Aldington and Mersham Support Group - Rule 17 Response 19_05_25

We note the Examiner's invitation to Interested Parties to comment in relation to the further question regarding Landscape Strategy and we are responding accordingly.

In relation to the Statement of Common Ground with Ashford Borough Council (ABC) at **Rep 8 – 016** we would highlight the following:

SLR evolution power
TYPE 1 PHOTOGRAPHY STONESTREET GREEN SOLAR REPRESENTATIVE VIEWPOINT PHOTOGRAPHS
SUMMER PHOTOGRAPHY
JOB NO: 404-011998-00001
DATE: MAR 2024 DRAWN: RSB CHECKED: JM APPROVED: JM
VIEWPOINT 31 DRAWING NO: PS-062

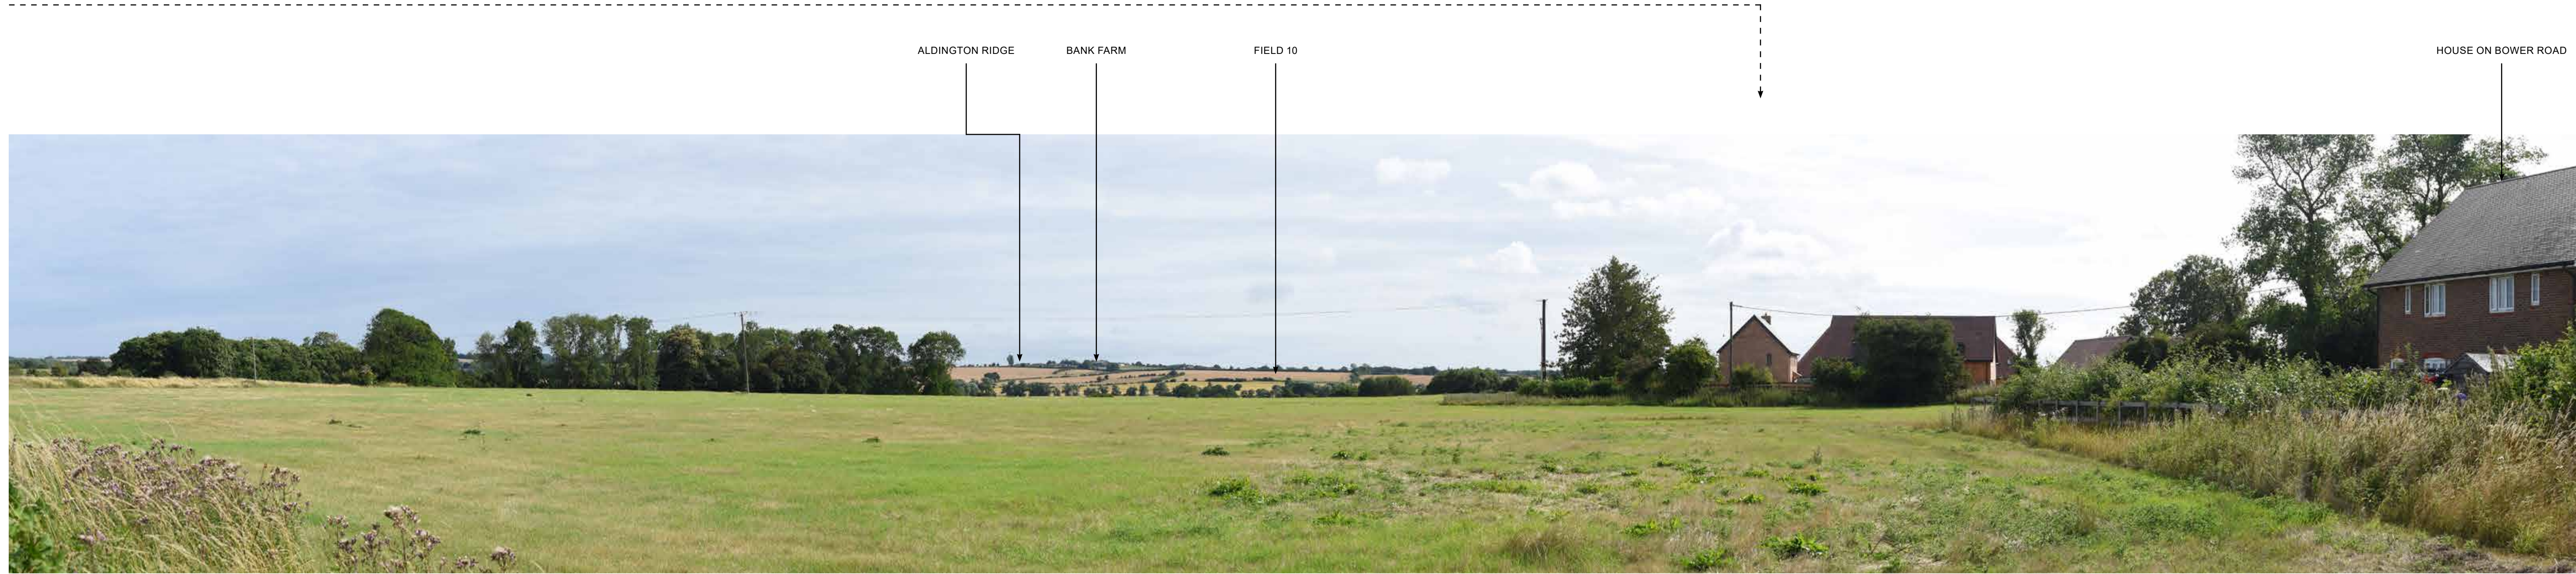
It remains the case that the Landscape Visualisations presented during the consultation process and as part of the DCO application are of insufficient resolution for the community and the Examiner to determine the visual impact of the proposed development.

It is not clear whether the Applicant has intentionally sought to obscure the true visual impact of the scheme or has not taken sufficient care to ensure that the resolution of the images meet the standards set by the Landscape Institute.

We have already made representations about the poor quality of the visualisations, but it is worth comparing the resolution of the following two images to emphasize the point.

The photograph below is an extract from **APP-082** Viewpoint 31(dated 17.05.2022 - existing 90° pano LVIA Summer). We have enlarged it to try and pick out features on Aldington Ridge. Just visible are, arrowed (1) the large Barn at Bank Farm, Bank Road and (2) Becket's Green, the white cottage on Bank Road. As can be seen, the buildings are very indistinct.

The low resolution of the landscape visualisations presented means that it is impossible to properly determine the visual impact of the solar and battery infrastructure that the Applicant intends to locate on the Aldington Ridge. The decision to locate a large part of the scheme on a hill is a strange one, but surely it is not an unreasonable to expect the visual impact this causes to have been properly demonstrated in an open and honest way from the outset.
